From: Amanda Scholes on behalf of Planning.Responses
Sent: 11 February 2021 09:00
To: Planning Scanning
Subject: FW: Pagham Parish Council response P/132/20/RES
Attachments: P.132.20.RES comments.docx

Response to P/132/20/RES – Land North of Hook Lane, Pagham – approval of reserved matters following P/30/19/OUT for 300no new homes, internal roads, footpaths & cycleways, car parking & landscaping. This application affects the setting of a listed building & falls within Strategic site H SP2, CIL Zone 1 (Zero Rated).

Pagham Parish Council resolved to **OBJECT** to this application. In ordinary circumstances paper copies would be provided to allow the Parish council to properly review the application. It is difficult to have a true appreciation on an i-pad/phone.

Project	Hook Lane, Pagham
Drawing	Site Layout
Client	Hallam Land
Job no.	HALL200505
Dwg no.	SL01
Author	AS
Status	PLANNING
Client ref.	
Date	June 2020
Revision	A
Scale	1:1000 at A1
Office	Romsey

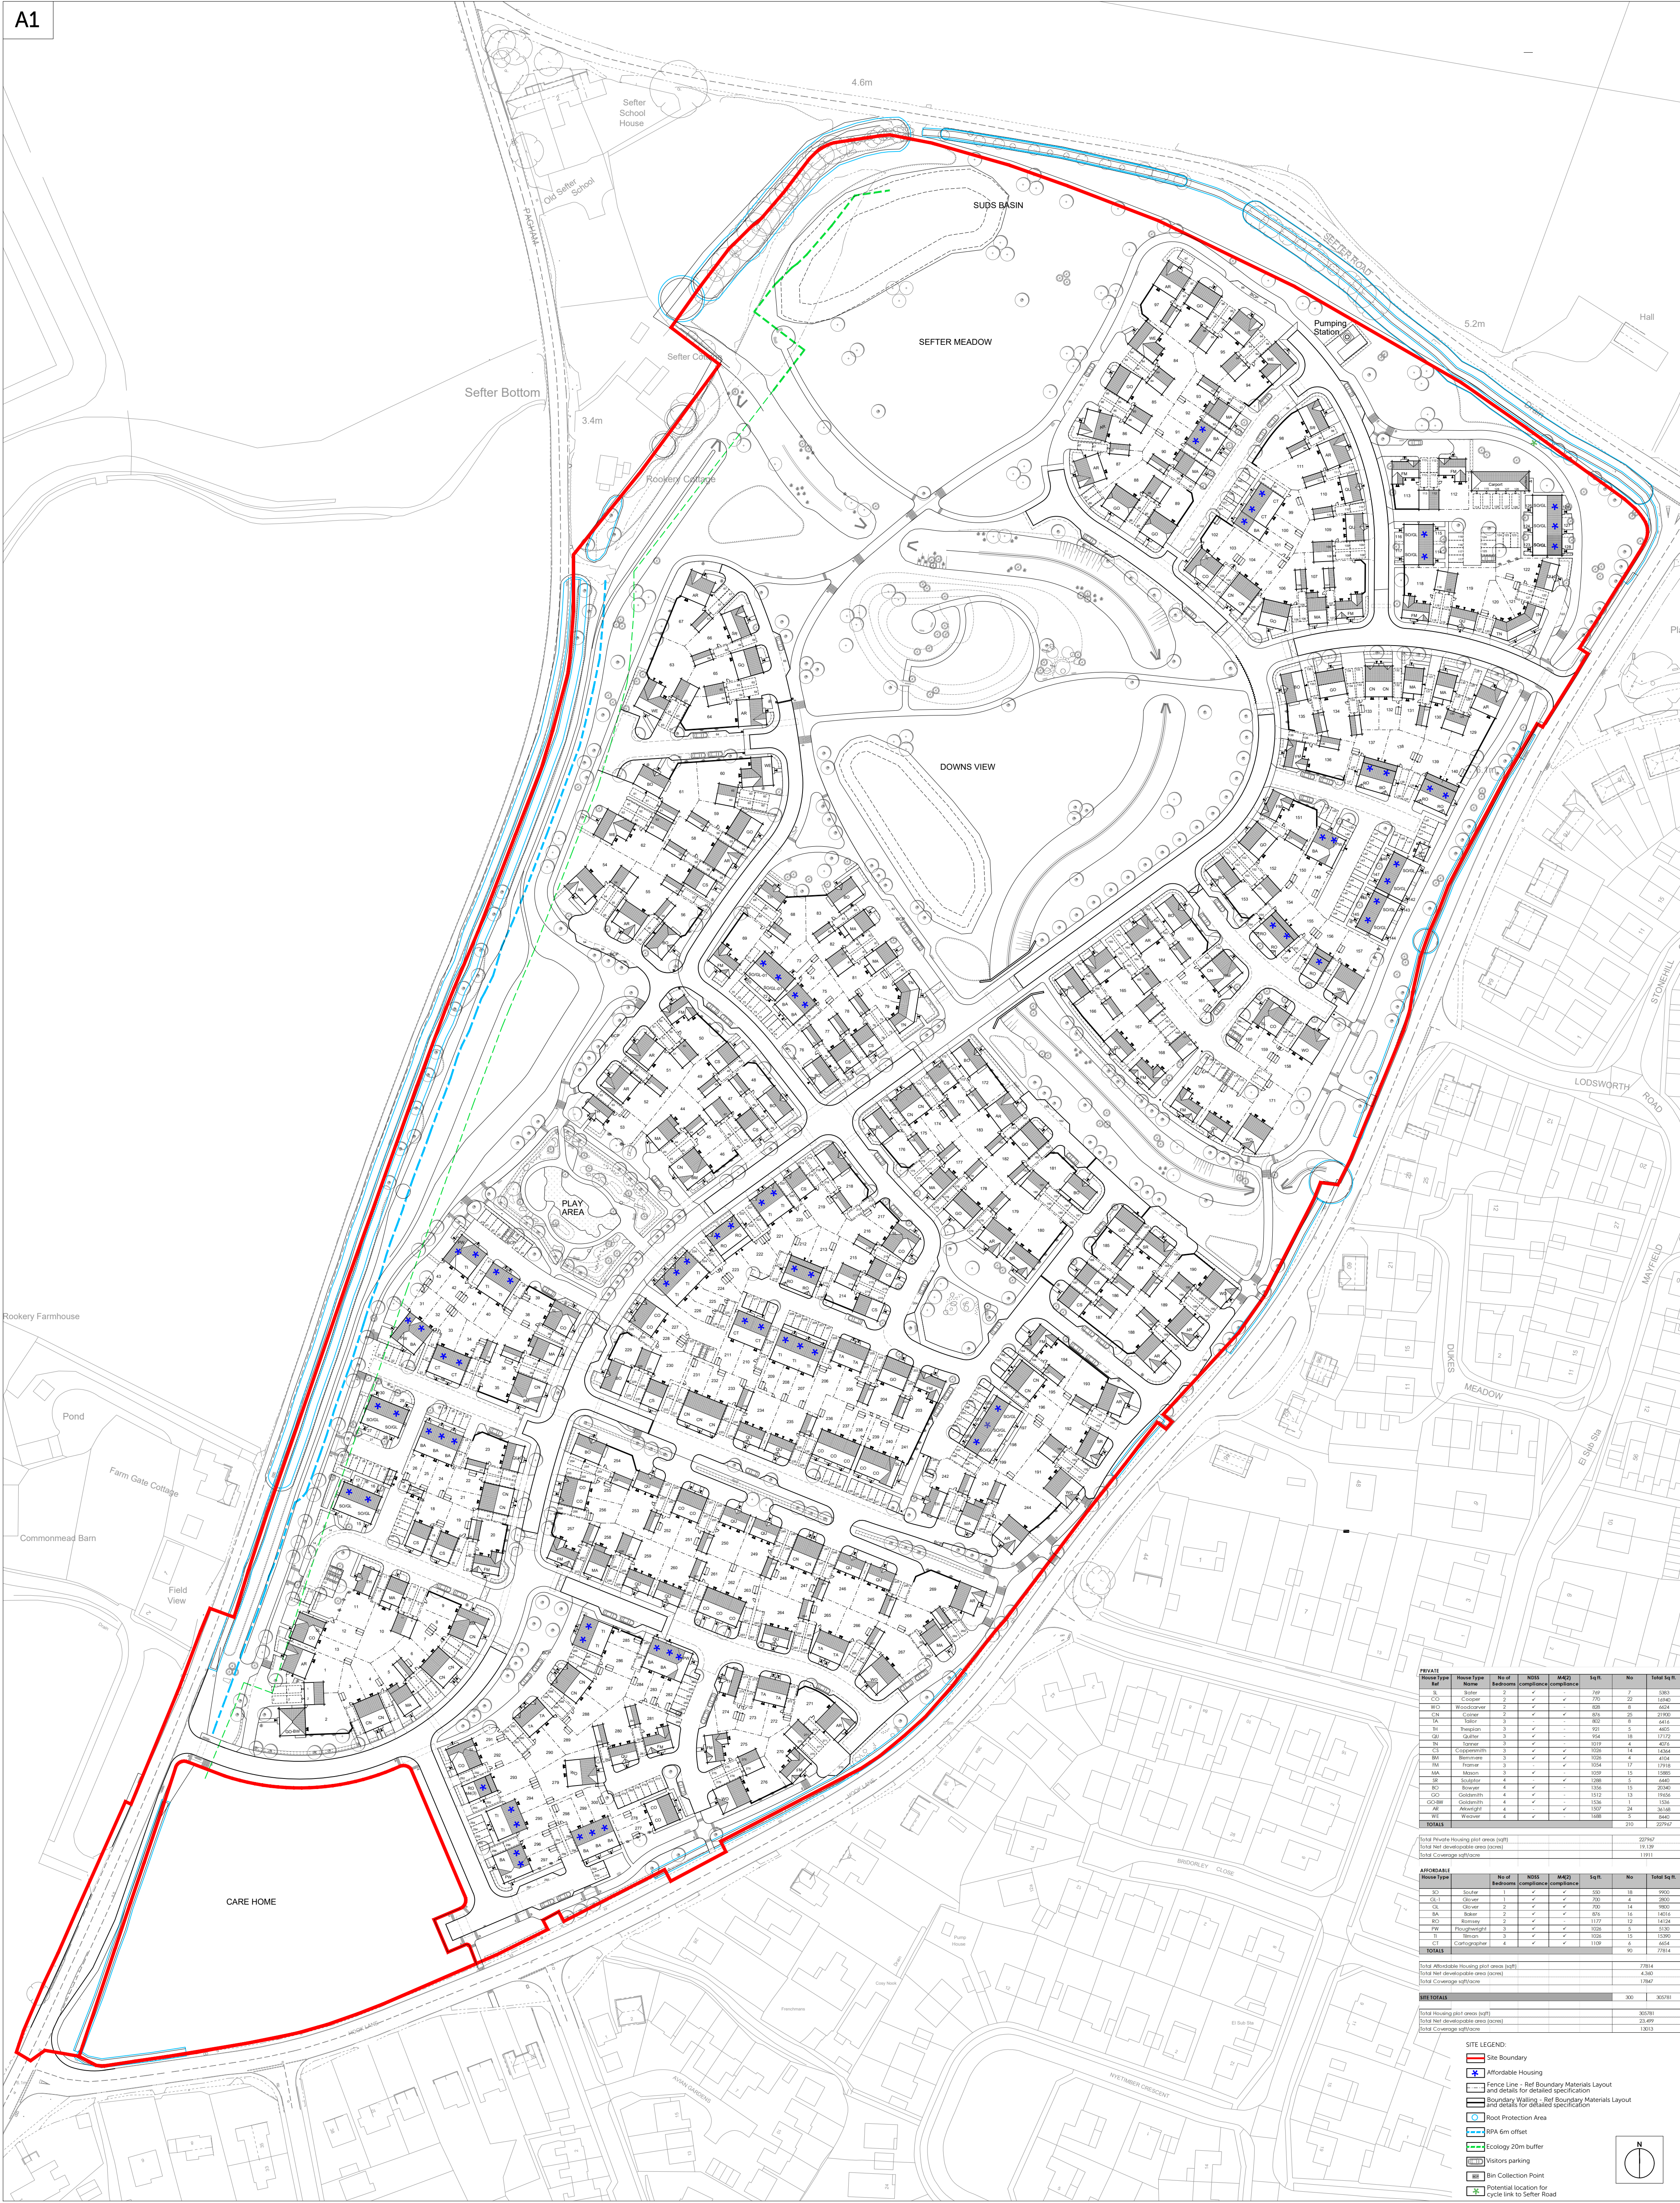
Pagham Parish Council supports the comments of WSCC Highways in relation to crossing points. It is inappropriate to have insufficient landing points at crossings on Hook Lane.

Concerns over the width of the roads – they are narrower than the Council would like to see. The issue can be that emergency services vehicles will not be able to navigate the road sufficiently quickly.
